EXHIBITION OF ENVIRONMENTAL IMPACT STATEMENT (SSD_5353)
CALTEX KURNELL PORT AND BERTHING FACILITY PROJECT, BOTANY BAY

The Environment Protection Authority (EPA) has reviewed the proposal and has no objection to the proposal proceeding as described in the EIS subject to the comments outline in this letter and attachment.

ENVIRONMENT PROTECTION AUTHORITY COMMENTS ON EXHIBITED ENVIRONMENTAL IMPACT STATEMENT

Figure 1-1: Project Site and Context (source: URS 2013)

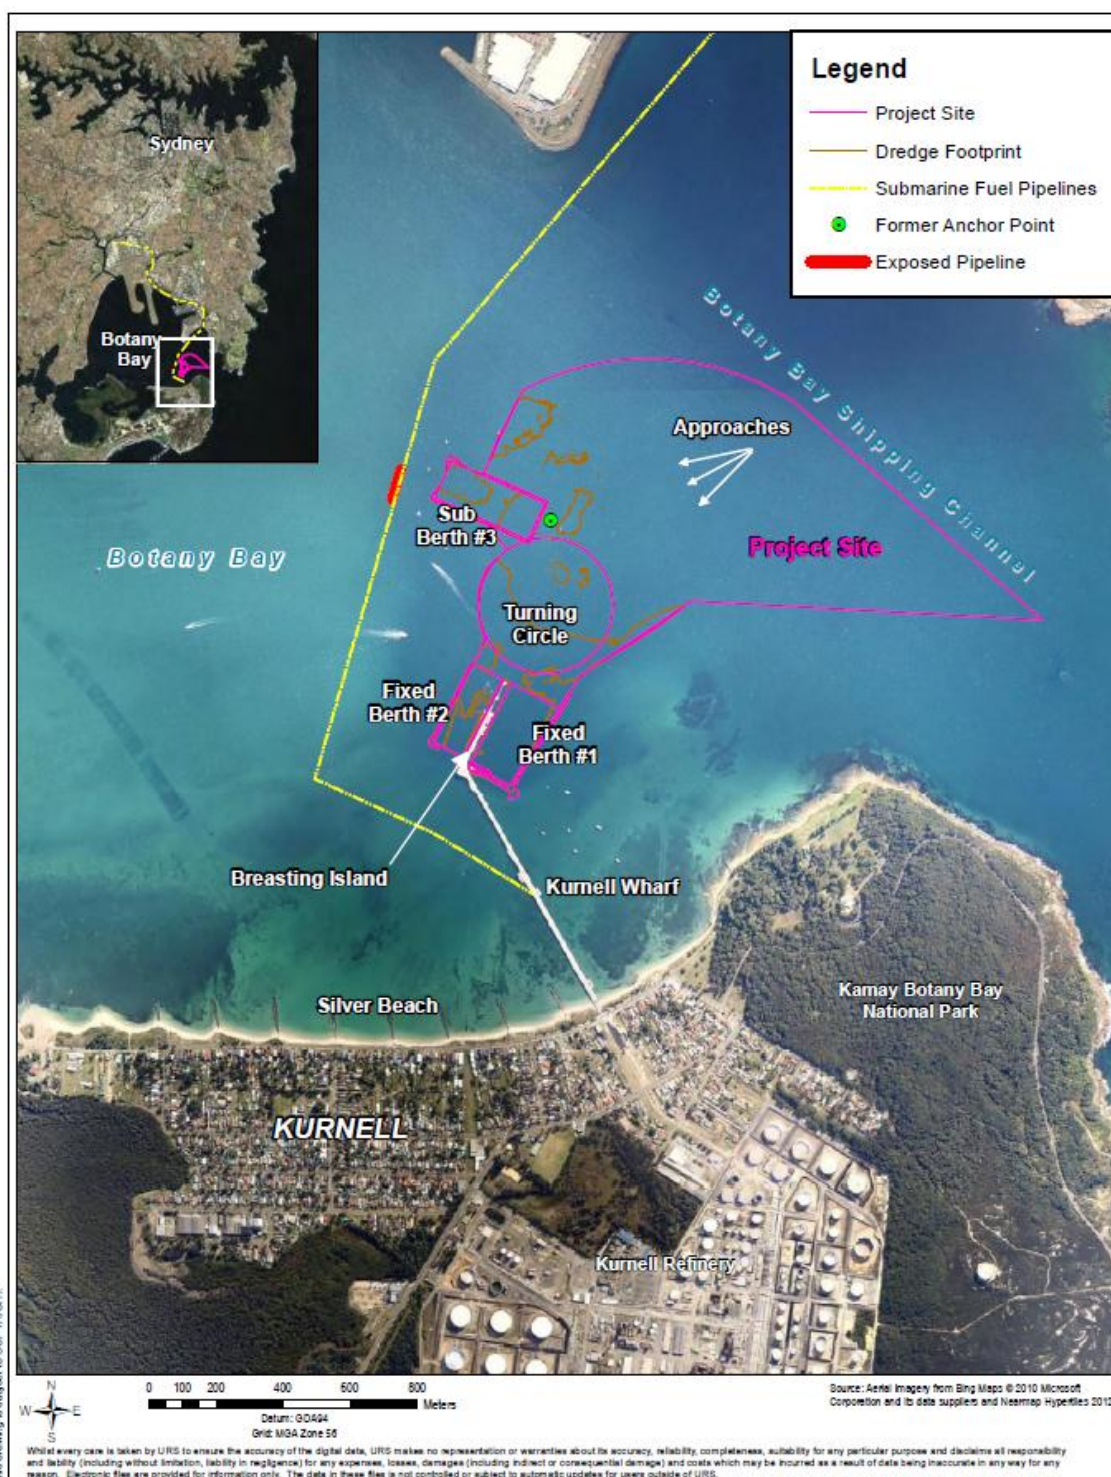
- Figure 4-6 shows the location of the Former Anchor Hole which will be filled with clean material during the dredging operations. Figure 1-1 shows a Former Anchor Point which is in a different location to Figure 4-6. It is unclear from the EIS whether these two points are the same or whether they are two separate reference points. Caltex should clarify this issue as Figure 1-1 has been included in a Caltex Community Information Leaflet in February 2013.
